**RESPONSE TO CITY OF SYDNEY COUNCIL PPR SUBMISSION
BLOCKS 1 AND 4, CENTRAL PARK**

This letter has been prepared on behalf of the proponent, Fraser Broadway Pty Ltd, in response to a submission received from City of Sydney Council (the City) dated 21 May 2013. This letter has been prepared specifically response to City of Sydney's submission relating to the Response to Submissions/Preferred Project Reports relating to Blocks 1 + 4, and the Concept Plan for Central Park. Specifically these applications include:

- Modification to the Concept Plan - MP06_0171 Mod 8;
- Modification to Blocks 1 + 4 - Project Application MP08_0254 Mod 4; and
- Proposed Student Accommodation to Block 4S - SSD 5700-2012.

Figure 1 – Separation distances between block 4N and 4S

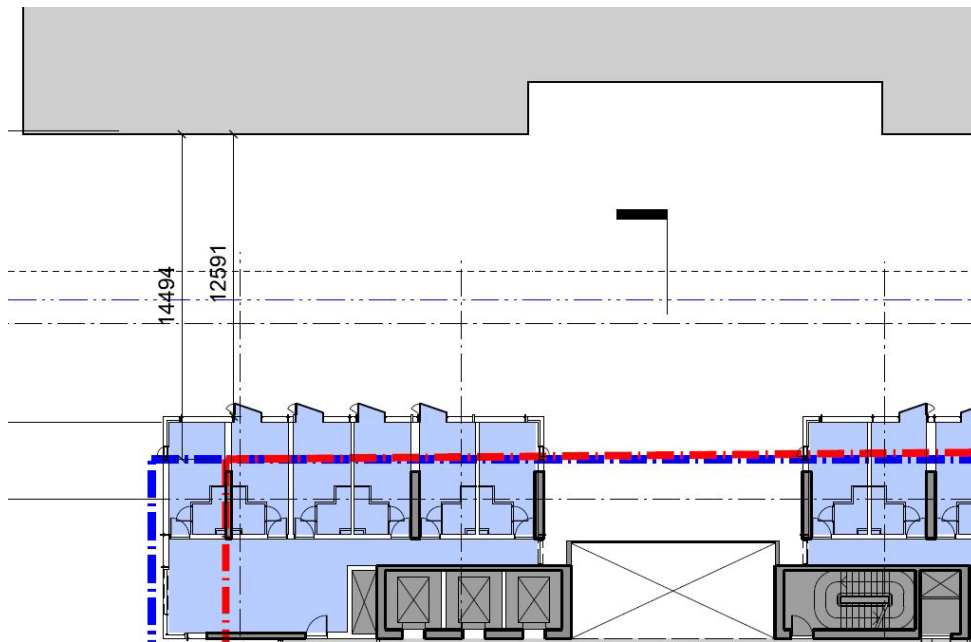
Requests for information have been misinterpreted by the City. In its response, the City refers the DPI's request for the proposal to be *"modified so that building separation between Blocks 4 North and 4 South comply with approved building envelopes"*. In the DPI Response to Submissions letter they asked for *"consideration to be given to increased separation between proposed buildings on Blocks 4N and 4S"*.

Due to the proximity of Block 4N and 4S as well as the size of the approved envelopes, along with the orientation of the buildings, a greater separation distance would have a negligible impact on improving the solar access afforded to the northern elevation of Block 4S.

The proposed separation between Block 4N and Block 4S is largely established by way of the existing approved Concept Plan. The design of the northern elevation of Block 4S as well as the public domain and landscape treatment provide a clear separation between these two buildings, whilst providing a high quality pedestrian link from Abercrombie Street into Central Park.

Figure 11: Proposed design of through site link between Block 4N and 4S with proposed cafe tenancy highlighted in red and recommended increase in retail tenancy highlighted in yellow

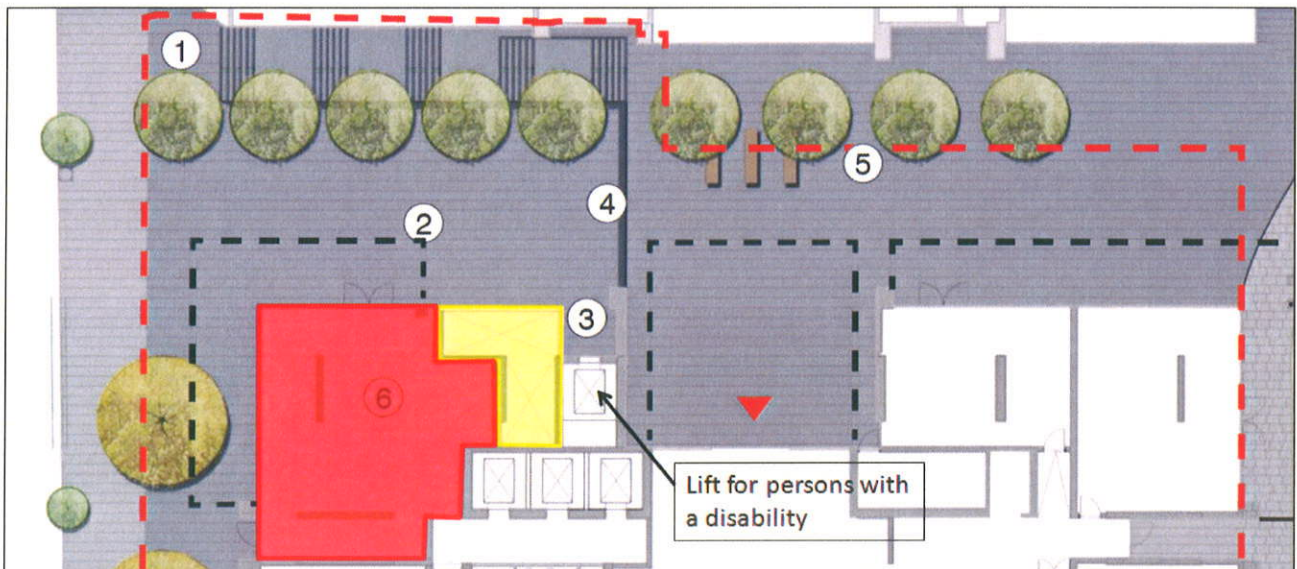
The City made comment regarding the pedestrian connections between Blocks 1 and 4N as well as between Blocks 4N and 4S. As part of the proposal, the link between Block 1 and Block 4N is proposed to be retained.

The design and arrangement of the publically accessible link between Block 4N and 4S is a result of detailed design and access considerations. The site falls approximately 3m from Central Park Avenue to Abercrombie Street. Following investigation and design development it was not considered feasible or practical to provide ramps for wheelchair access (given the gradient).

To ensure equitable access was maintained, a publically accessible elevator is provided between Abercrombie Street and Central Park Avenue. The proposed arrangement allows for an additional and active northern elevation at street level – improving the building connection and interaction between Abercrombie Street and the public link that would most likely not have been possible with a different design given the topography. As mentioned by the City, the proposed arrangement also allows a space for a public art feature to the wall that will be visible from Abercrombie Street.
